City of Albuquerque

UTILITY DEVELOPMENT DIVISION
HYDROLOGY SECTION
(505) 768-2650

February 3, 1987

RE: DRAINAGE PLAN FOR AZUELAS WOODS (J-14/067)
RECEIVED JANUARY 28, 1987

DRAINAGE & GRADING PLAN

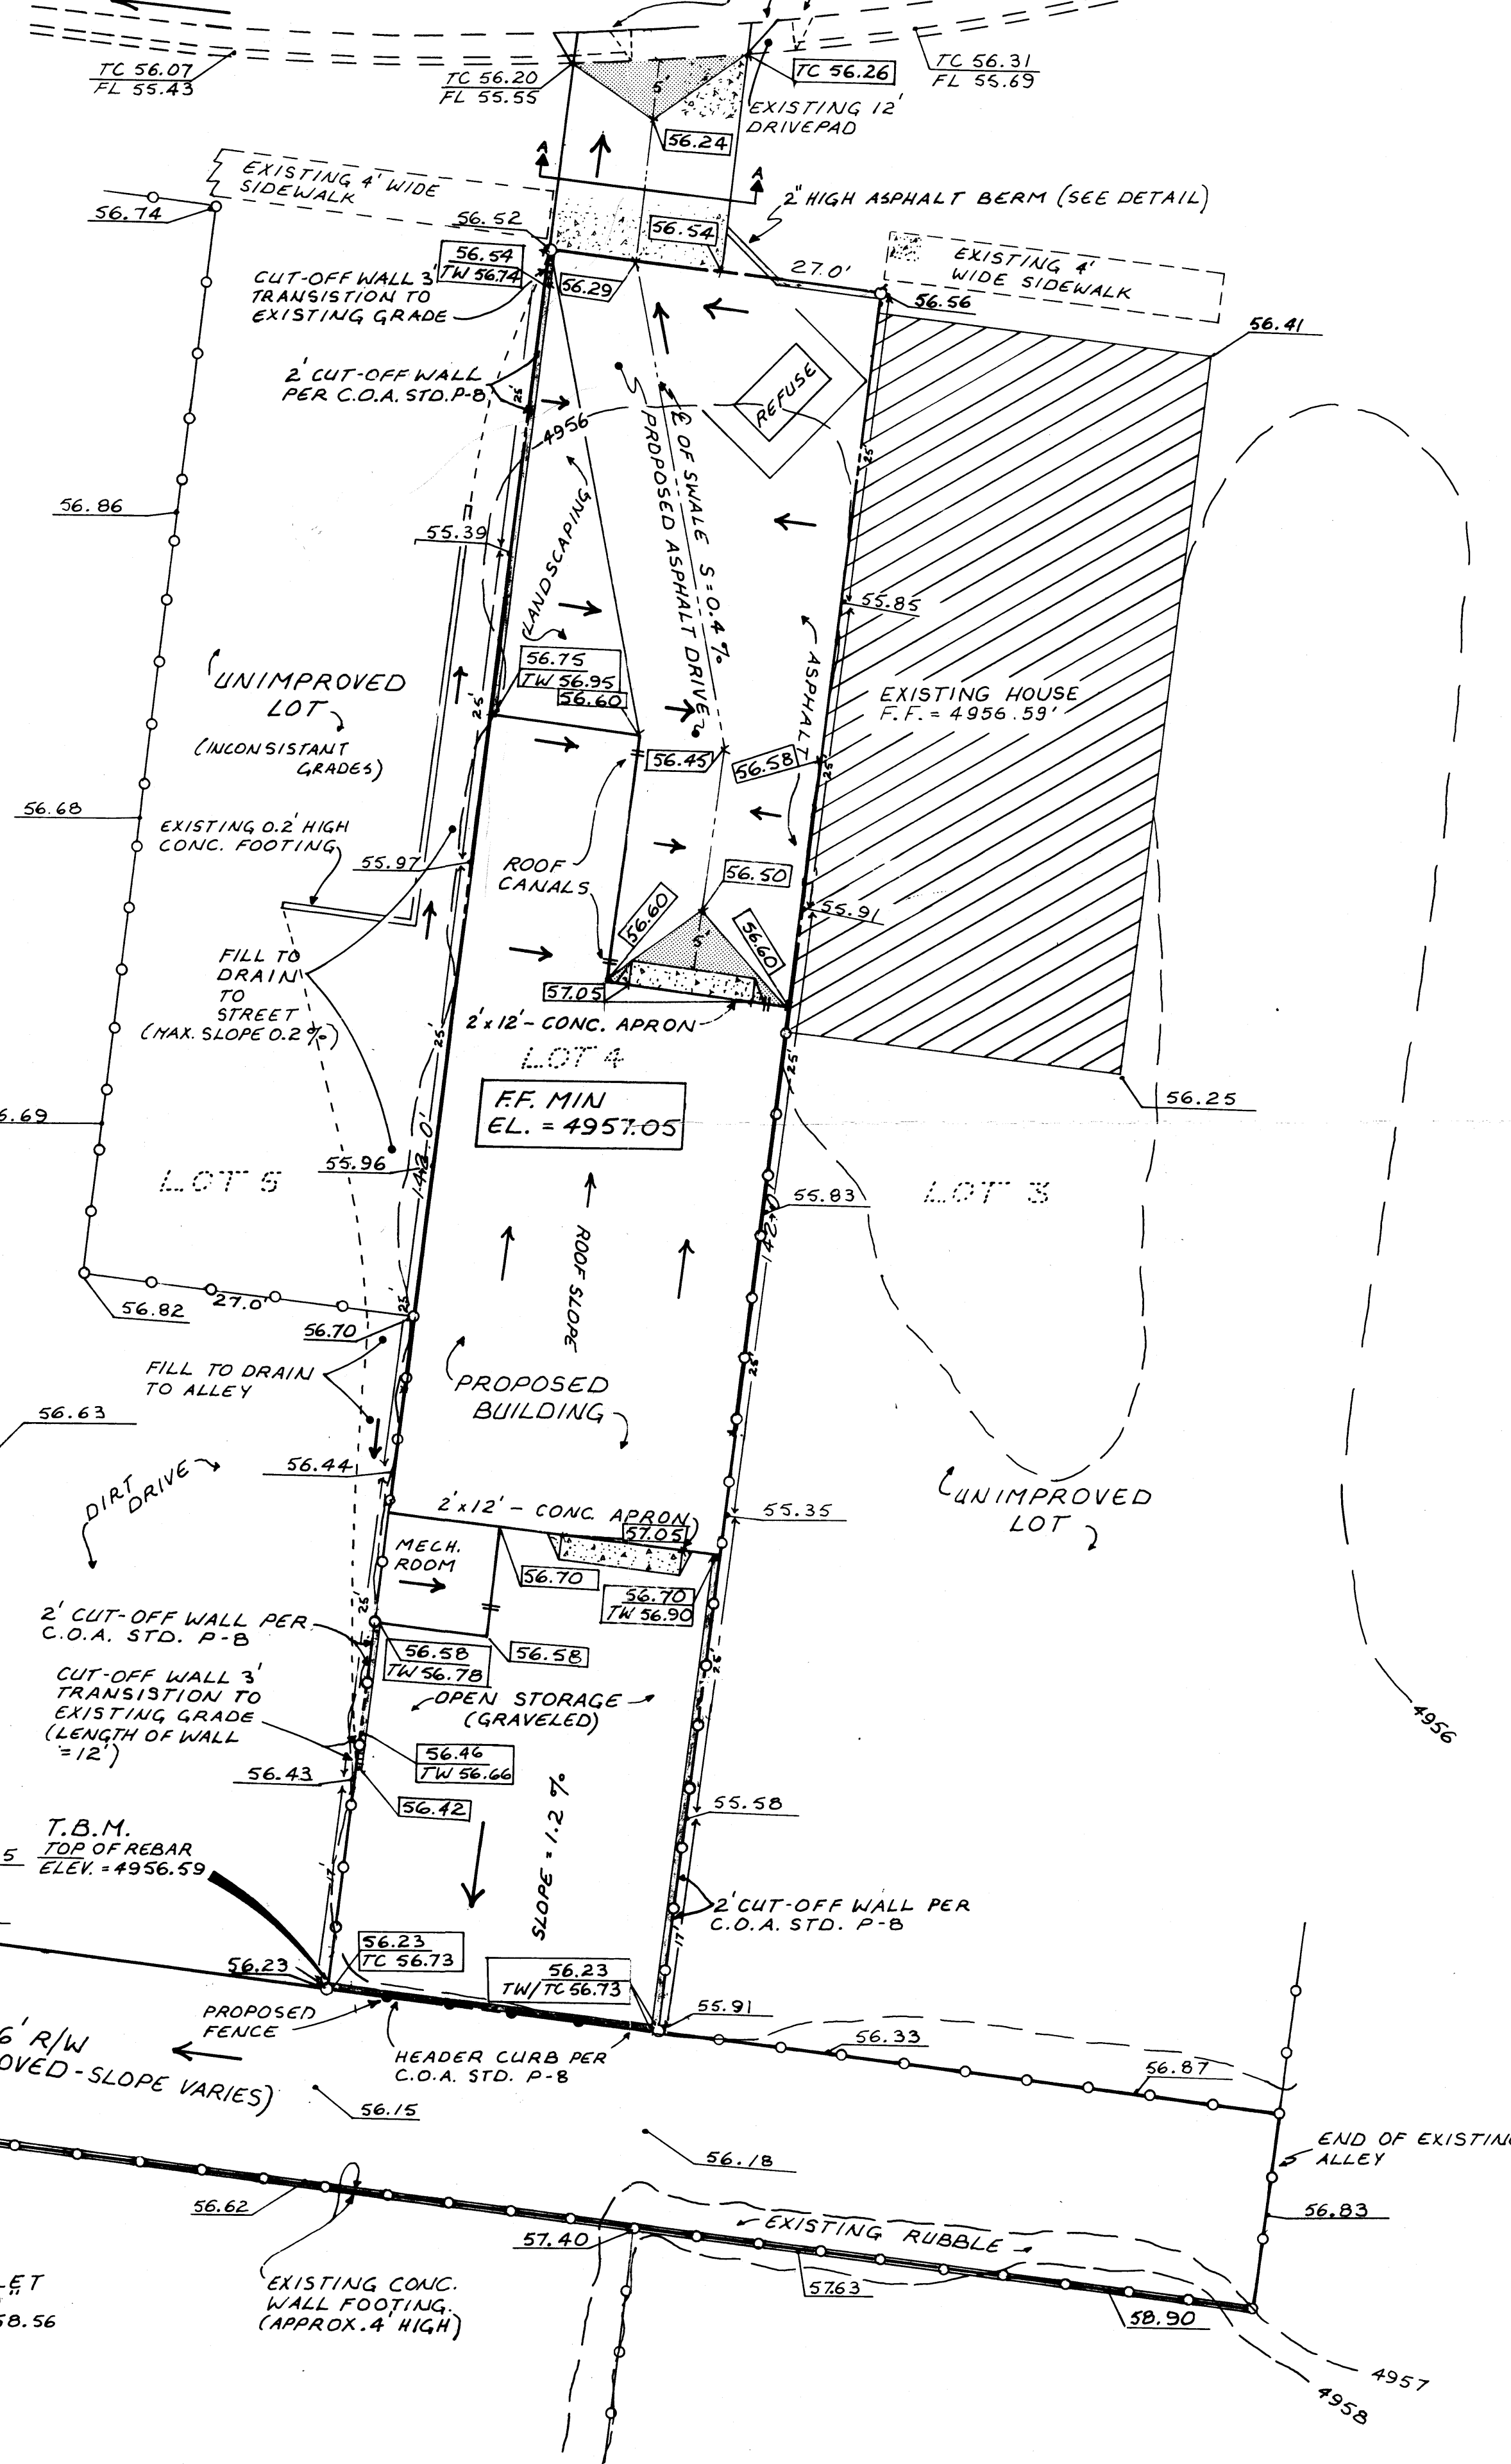
1. Building Permit will not be issued until first review of W.O. by DRD is conducted (confirmation required).
2. Drainage Plan shows that the proposed building will be blocking off-site flows from Lot 5. Any construction done outside the property (Lot 4) boundaries will require concurrence from the owner. By Ordinance, you are not allowed to block off-site flows.

1. Please show full calculations for determining the undeveloped, developed and volume rates. Volume calculations must be done using the SCS curve numbers.
